DRB CASE ACTION LOG (PREL/FINAL)

DRB Application No.: 07DRB-70298

Project # 1005465

Project Name: SOUTH BROADWAY INDUSTRIAL ACRES

**PLAT OF
TRACTS C-1 AND C-2
SOUTH BROADWAY INDUSTRIAL ACRES**

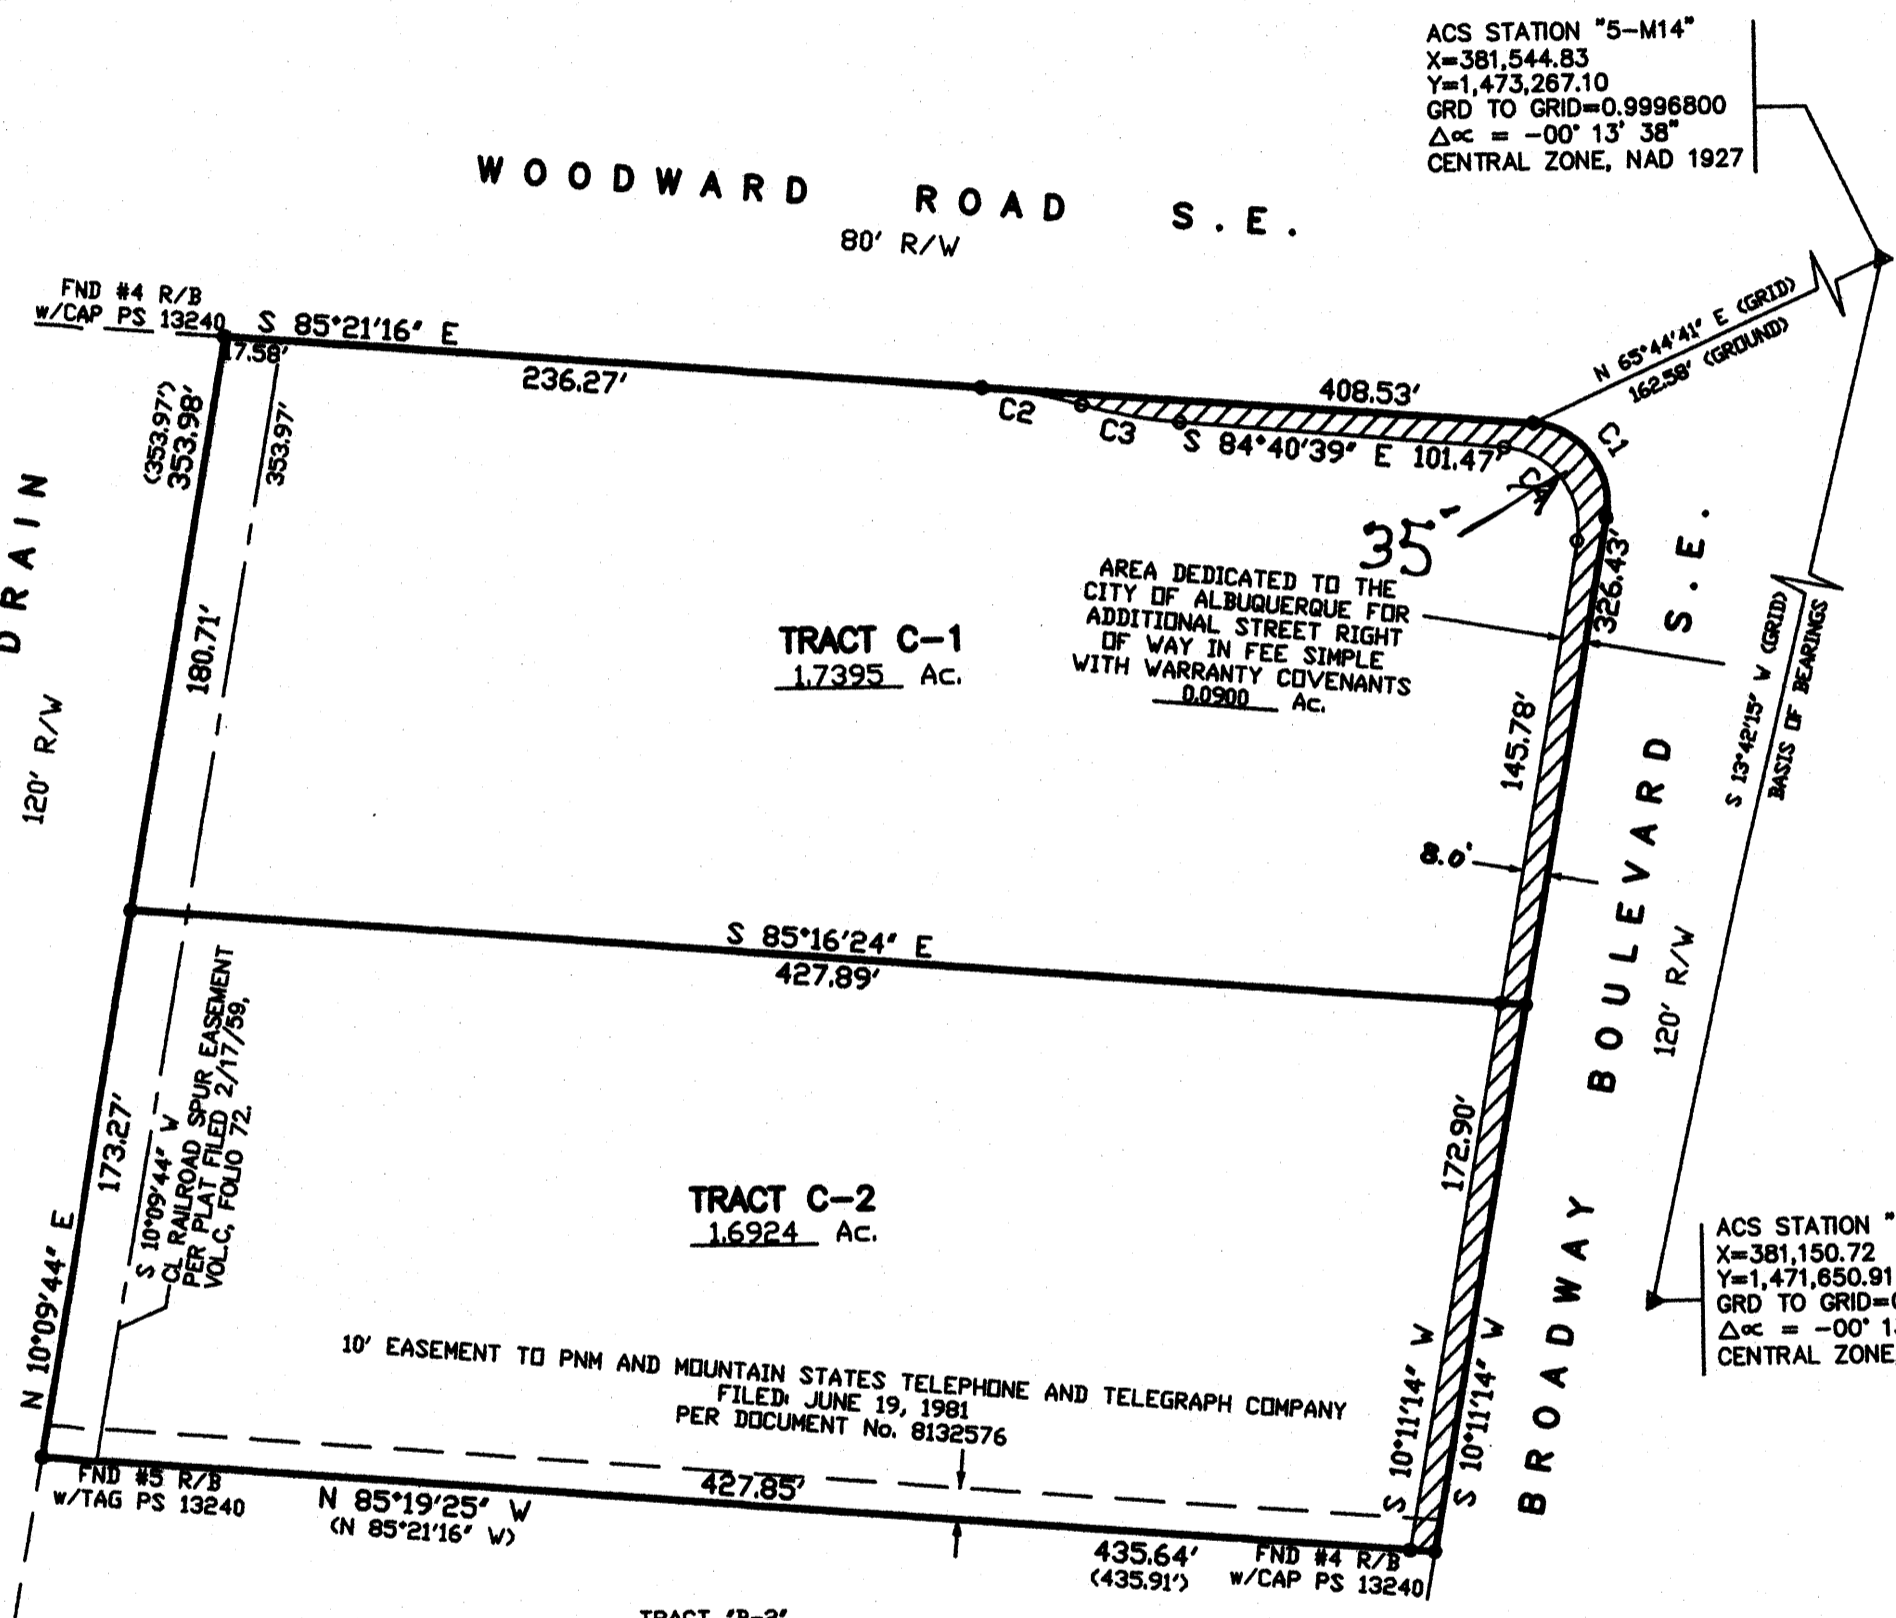
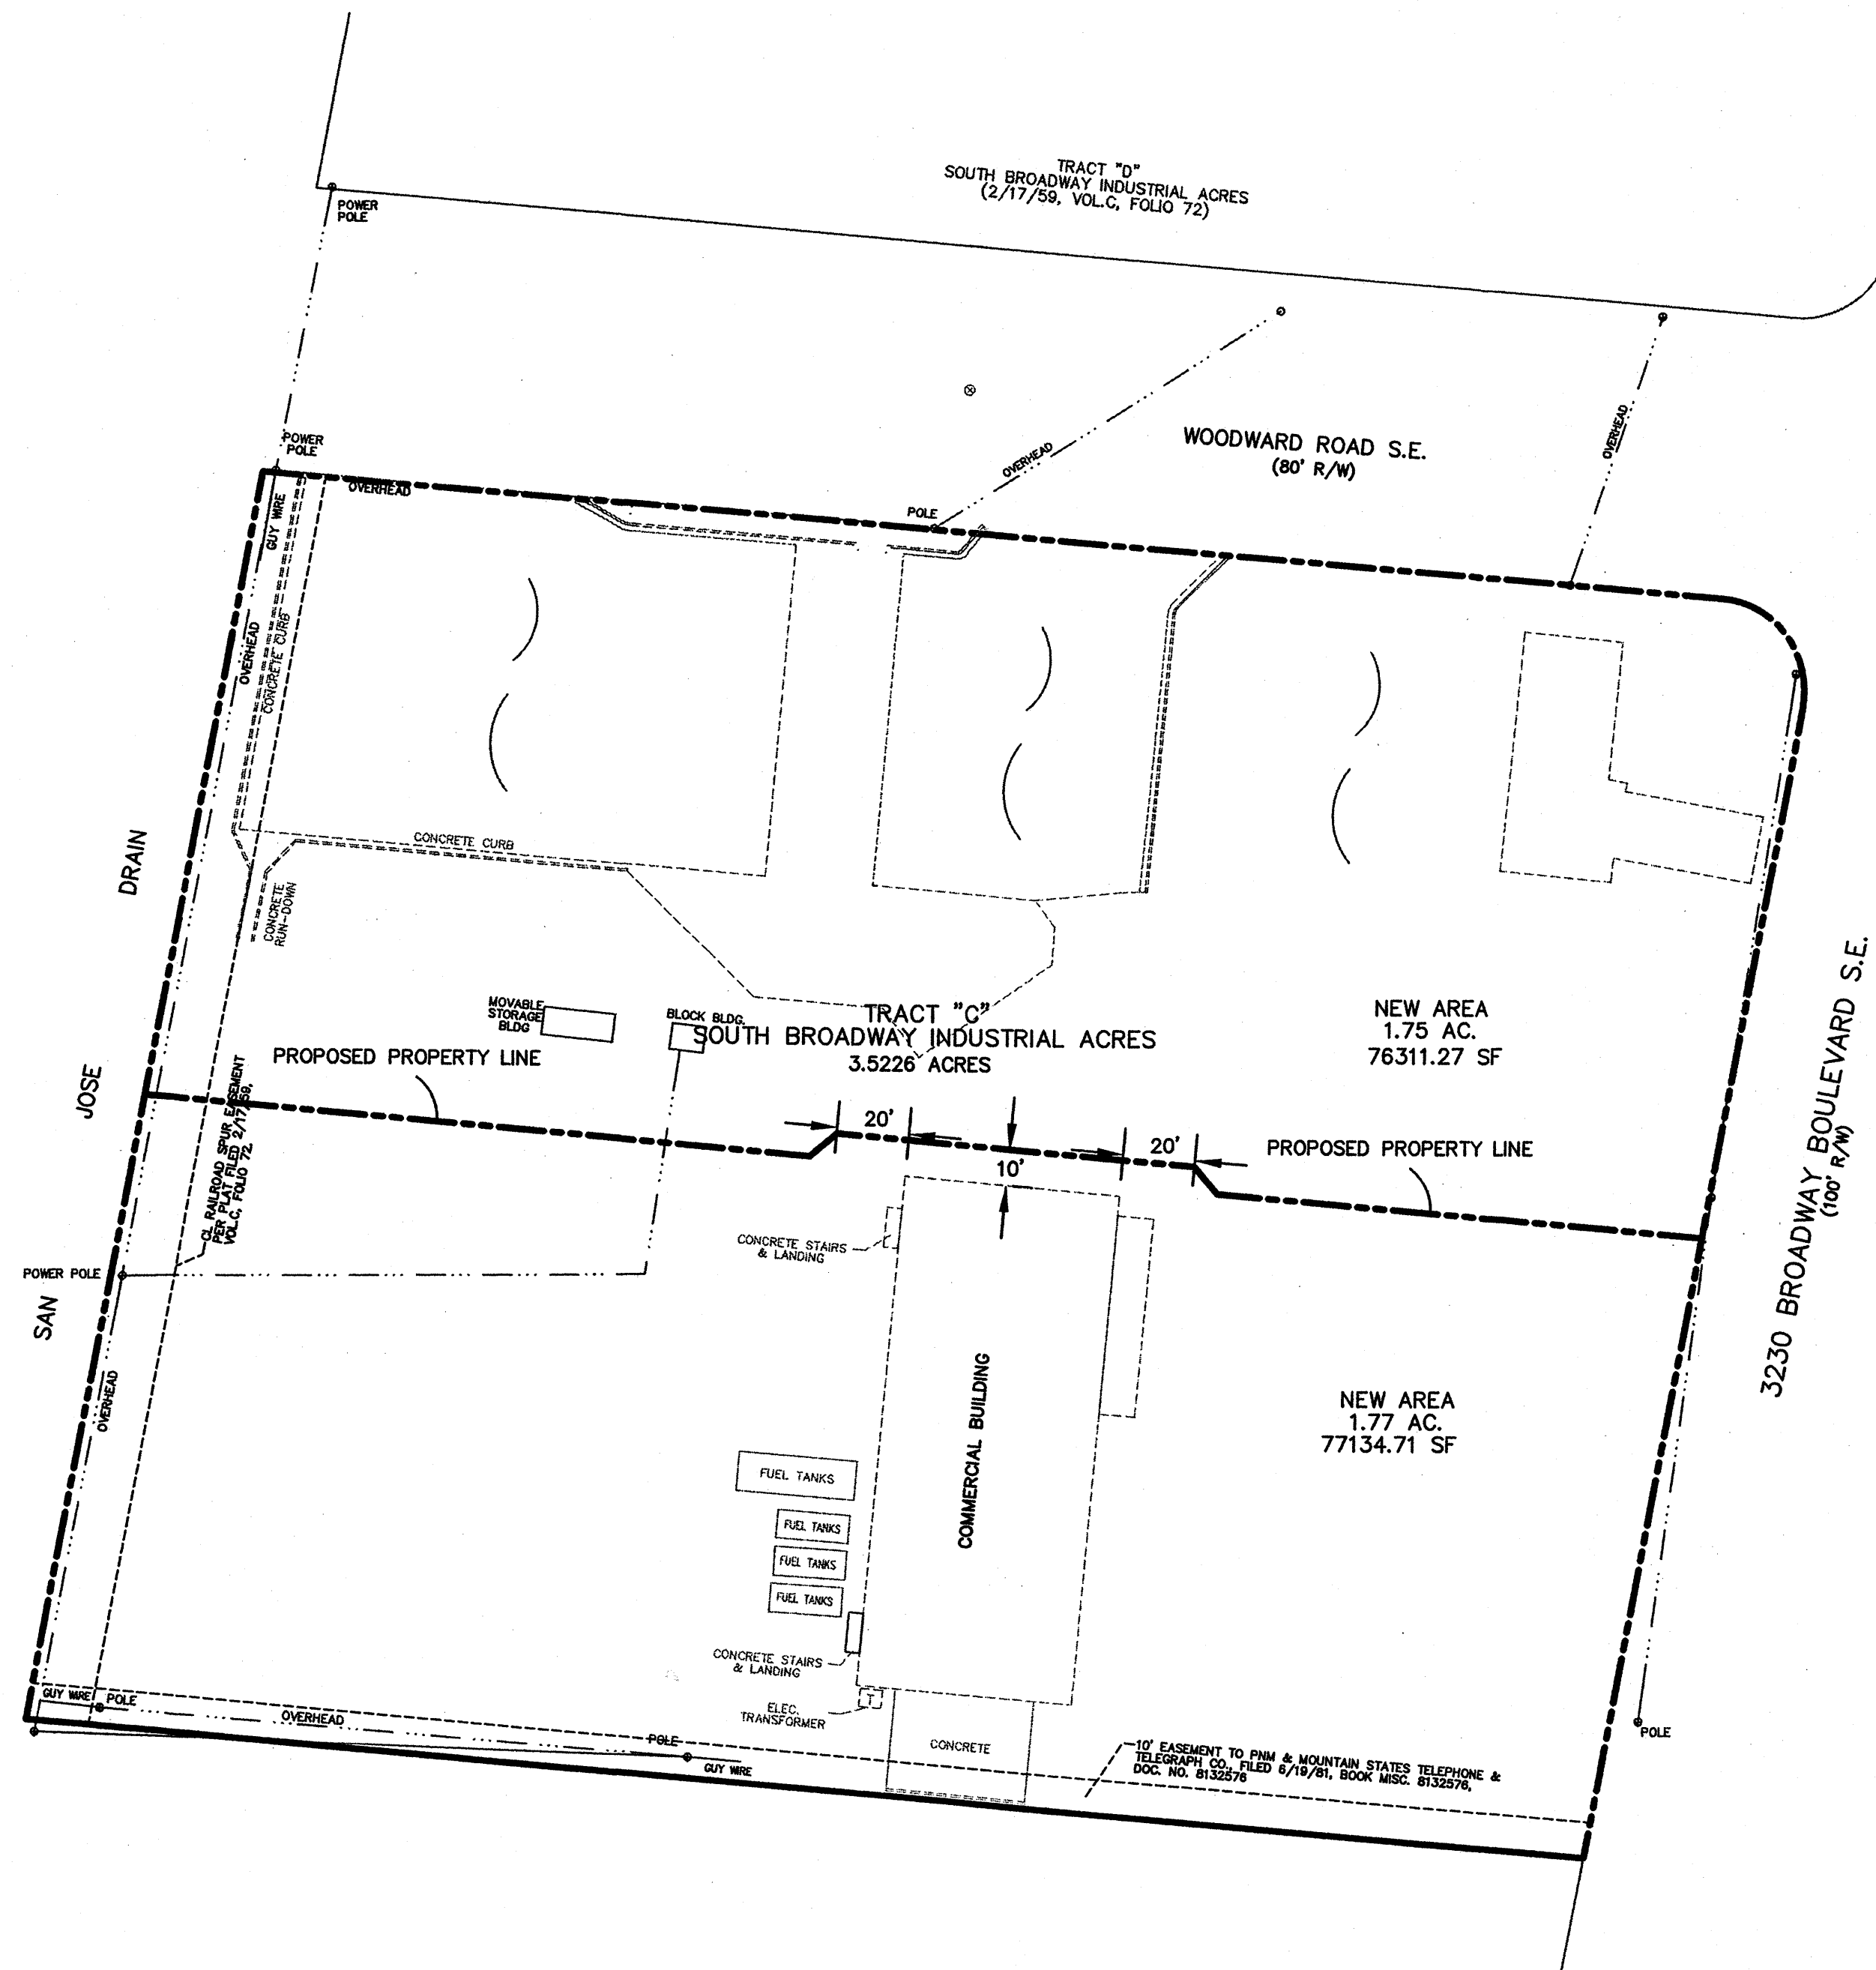
TRANSPORTATION: Curve C1 to be increased to 35' radius;
call out width of ROW dedication on Woodward Rd;
provide Woodward Rd cross section

Woodward Road – Collector, Broadway Boulevard – Principal Arterial
Additional right of way must be dedicated to the City of Albuquerque

- Curve C1 to be increased to a 35 foot radius
- Required right of way for principal arterials in established urban and central urban areas is 124 feet – dedicate an additional 12 feet of right of way along Broadway frontage – *Prev decision – 136' ROW*
- An additional 12 foot right turn lane is to be added to Woodward Road – dedicate the appropriate right of way

Provide a cross section for Woodward Road ~~road~~ – *show width of ROW dedication*
Broadway Blvd - 120' ROW currently, dedicate addn'l 8' of ROW
